**From:** Speakman, Glenn - Oxfordshire County Council  
<Glenn.Speakman@Oxfordshire.gov.uk>  
**Sent:** 20 January 2022 11:12  
**To:** Michael Sackey; DC Support  
**Cc:** Transport CDC Minor; Cllr Ian Corkin  
**Subject:** 21/04134/F Part Of OS Parcel 5720 East Of Kyleburn And West Of Manor Farm,  
Main Street, Wendlebury

**Planning application:** 21/04134/F  
**Location:** Part Of OS Parcel 5720 East Of Kyleburn And West Of Manor Farm, Main Street, Wendlebury  
**Description:** i) Relocation of existing field access, and,  
ii) Permanent closure of existing gateway.  
**Case Officer:** Michael Sackey

LOCATION and BLOCK PLANS As Existing & As Proposed
1:2500 1:500 1:100 TPH December 2021
Original at A1 Drwg no. 21 / 199.01

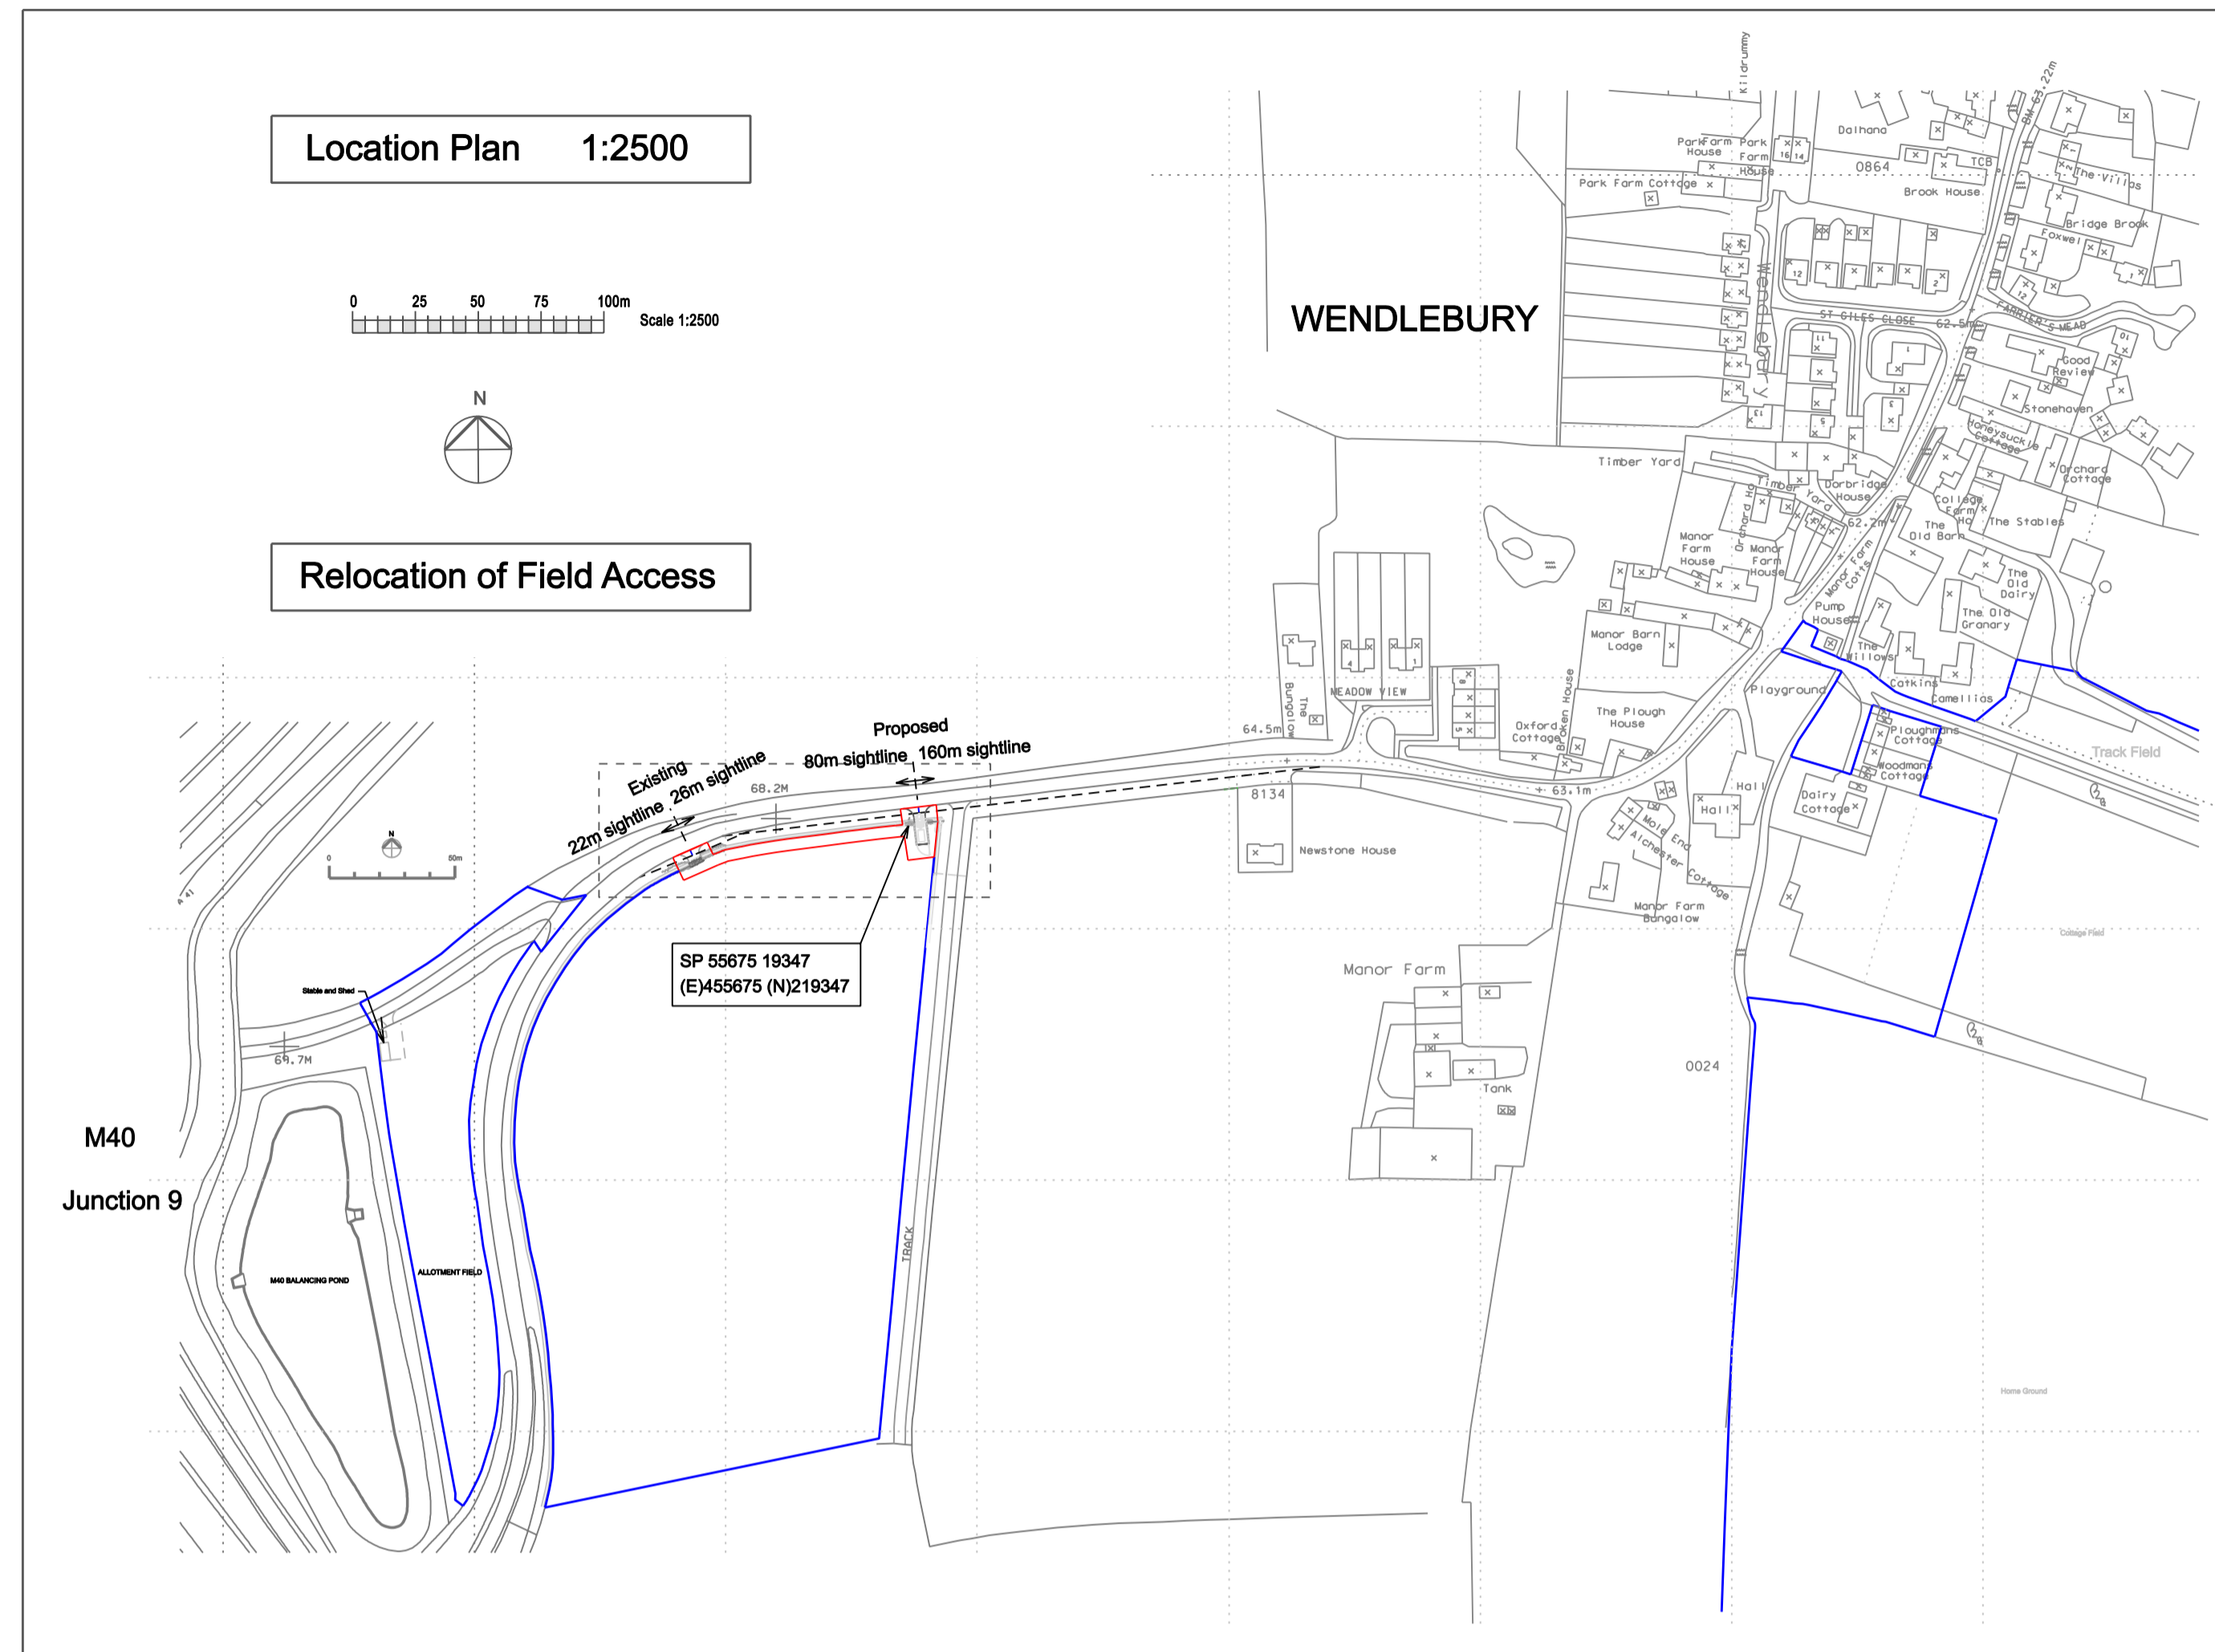
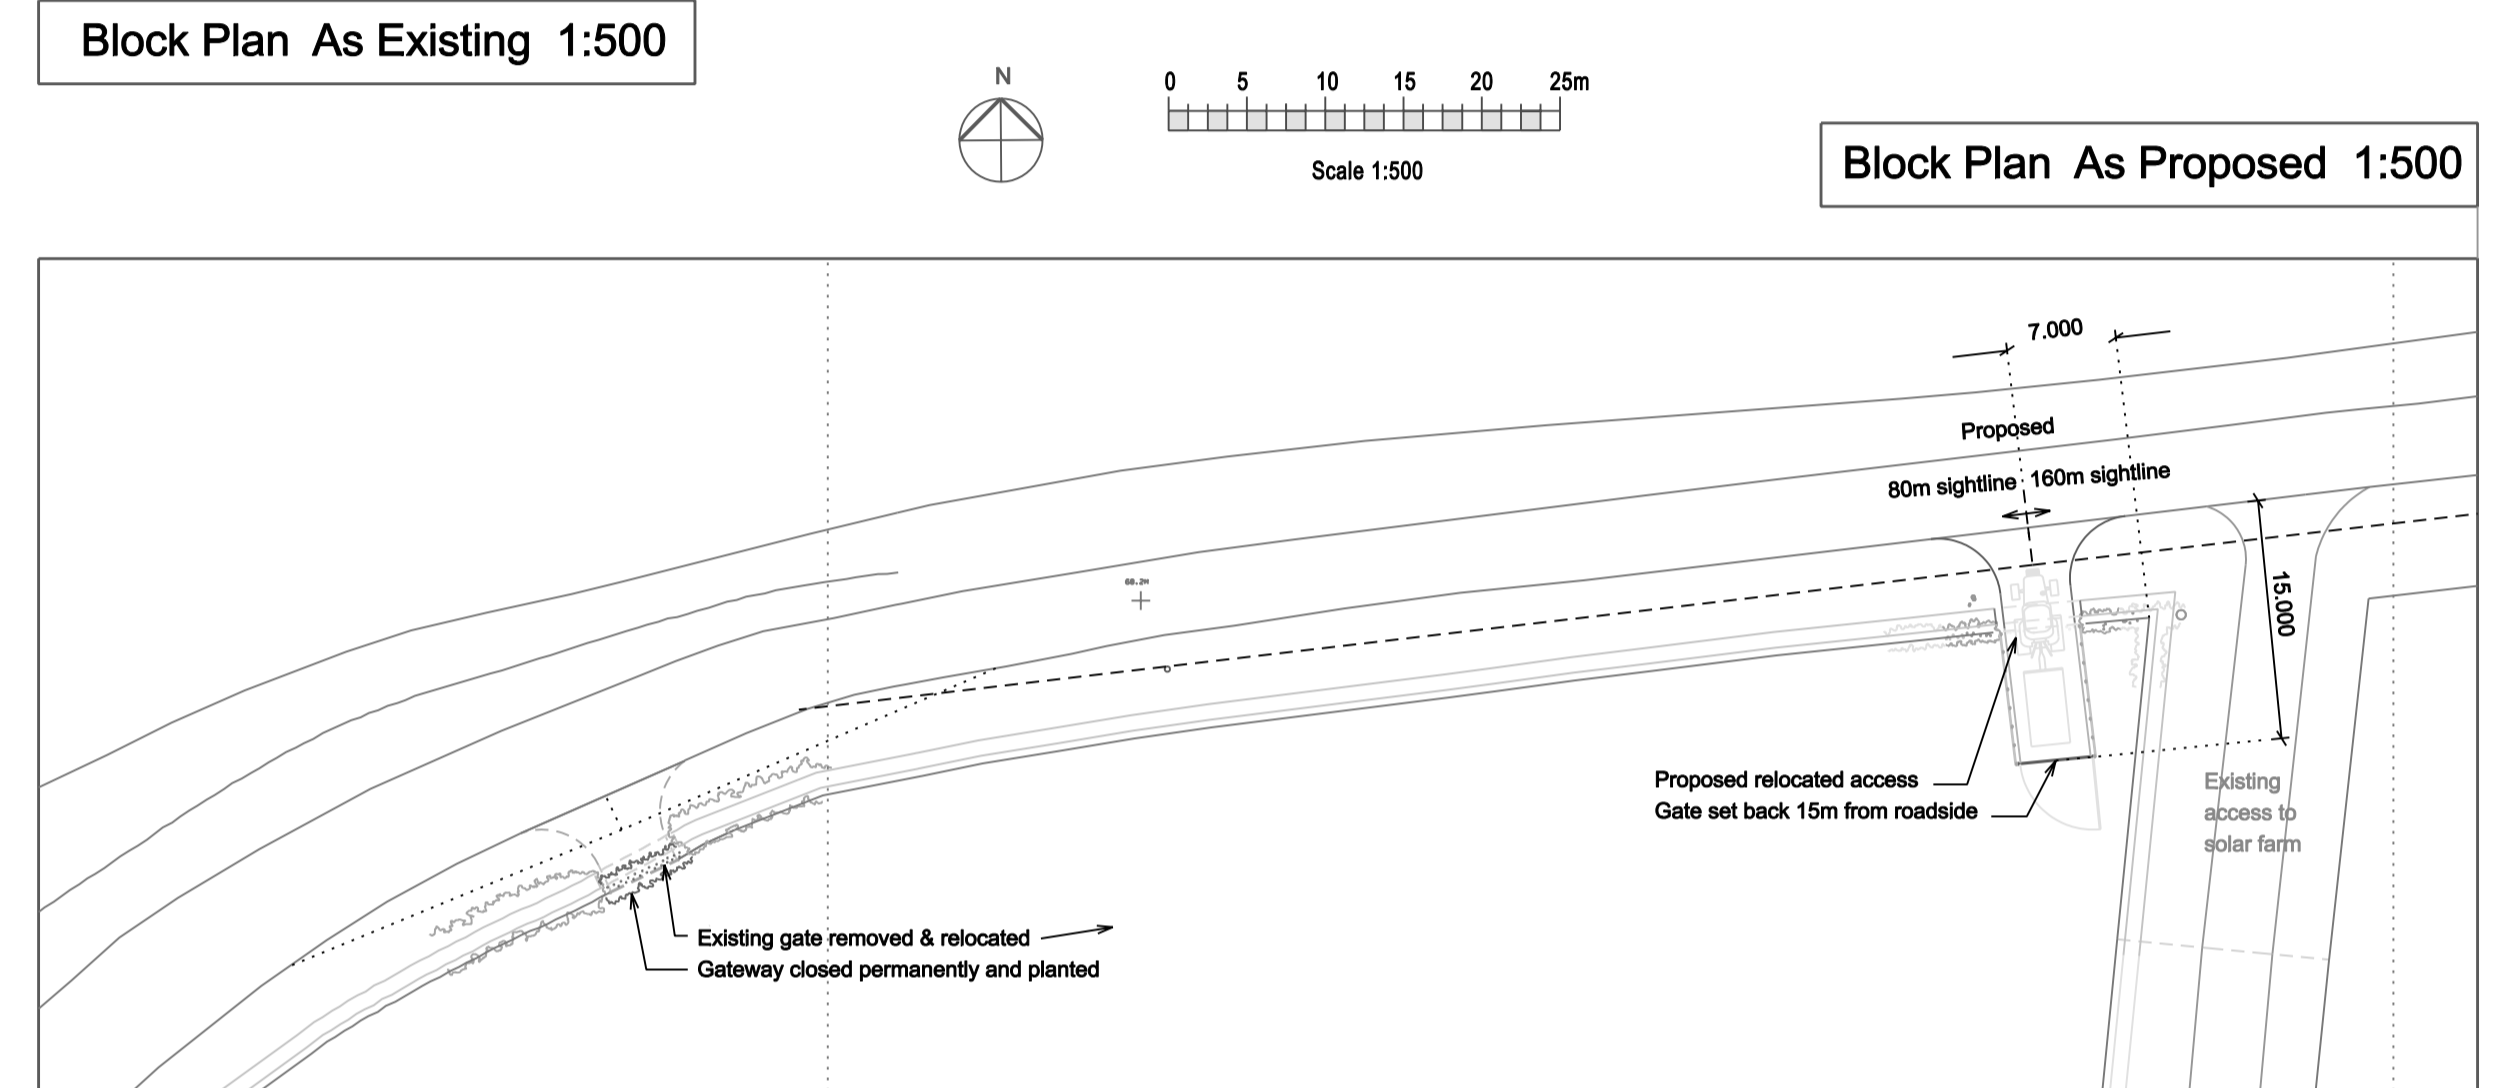
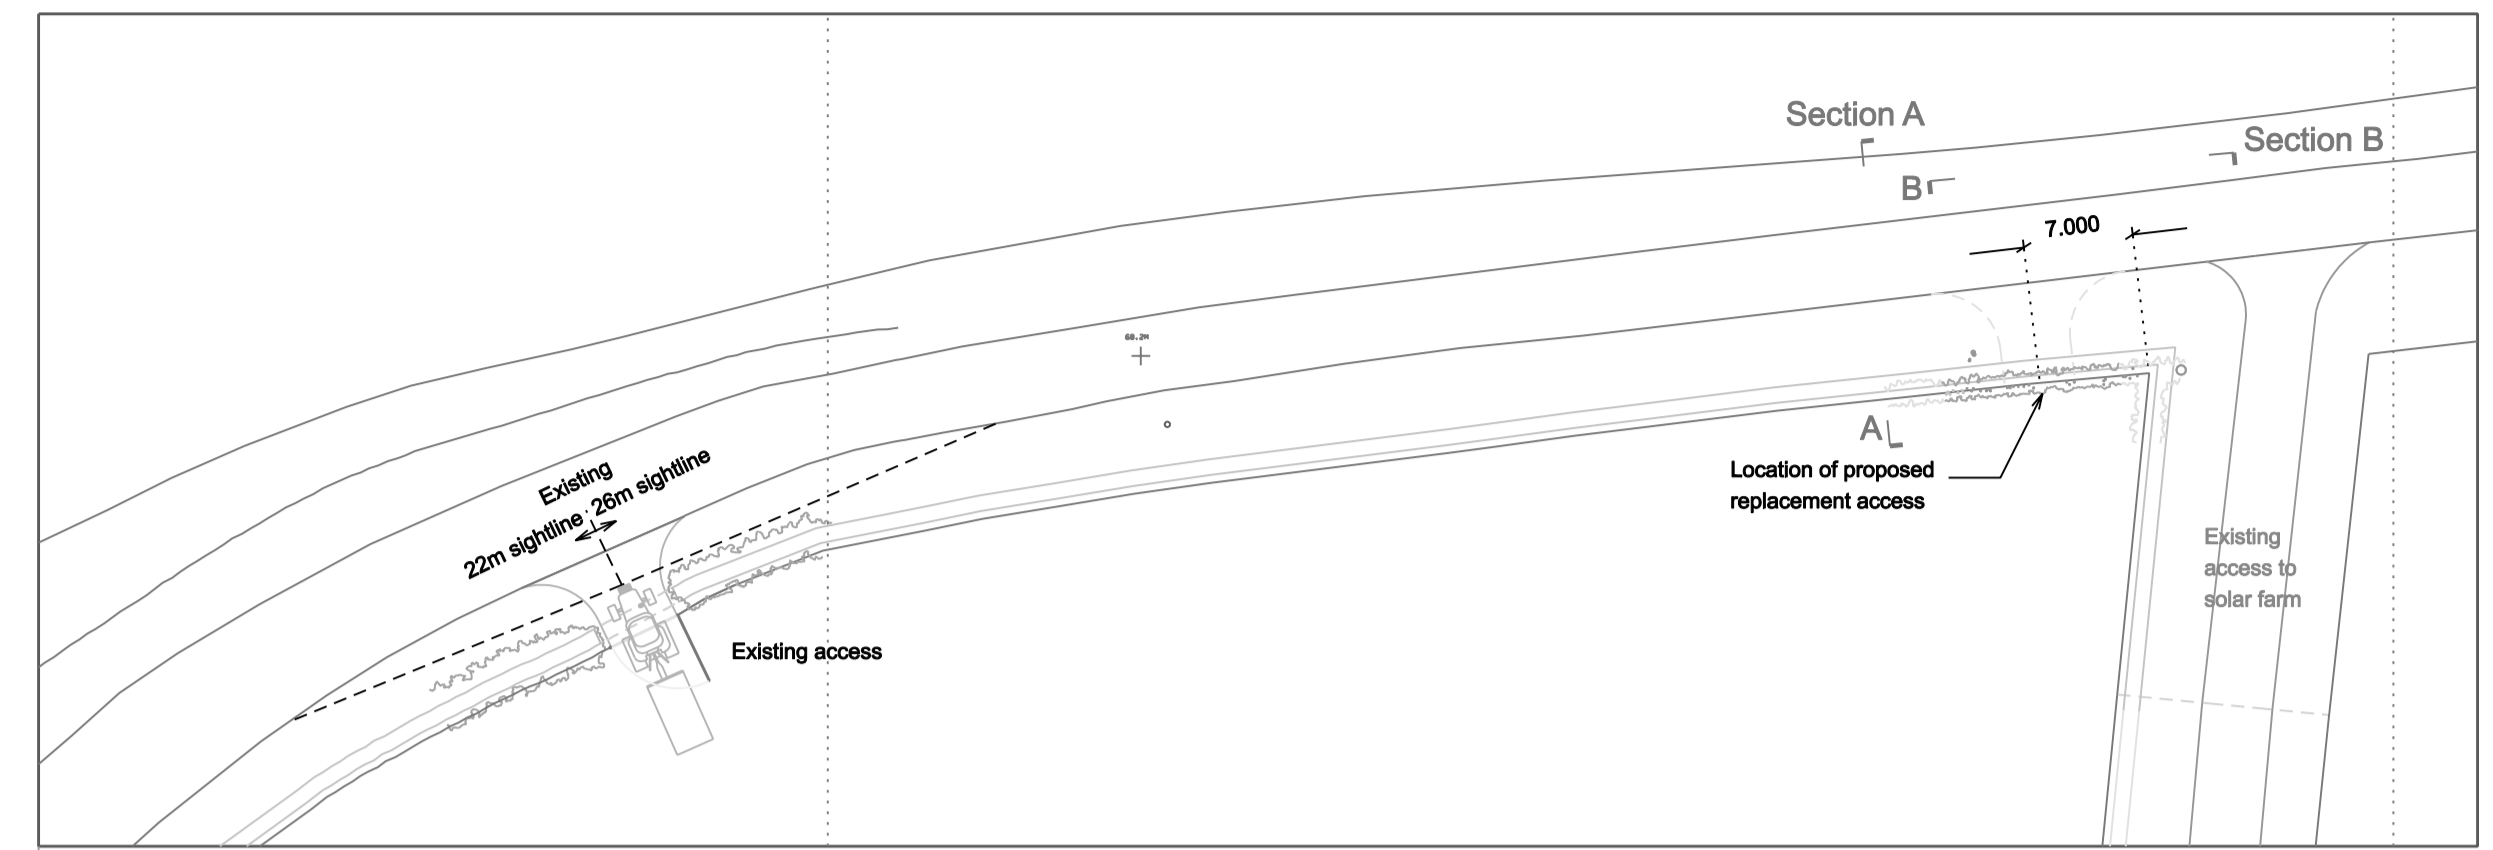
The proposals represent a severely sub standard access being improved and made substantially safer. The western splay of 80m would still be considered sub standard according to guidelines. Despite this, the access has been relocated into the best possible position and the application will not increase the number of vehicle trips at the access.

The proposals are therefore unlikely to have any adverse impact upon the local highway network in traffic and safety terms, OCC do not object to the granting of planning permission.
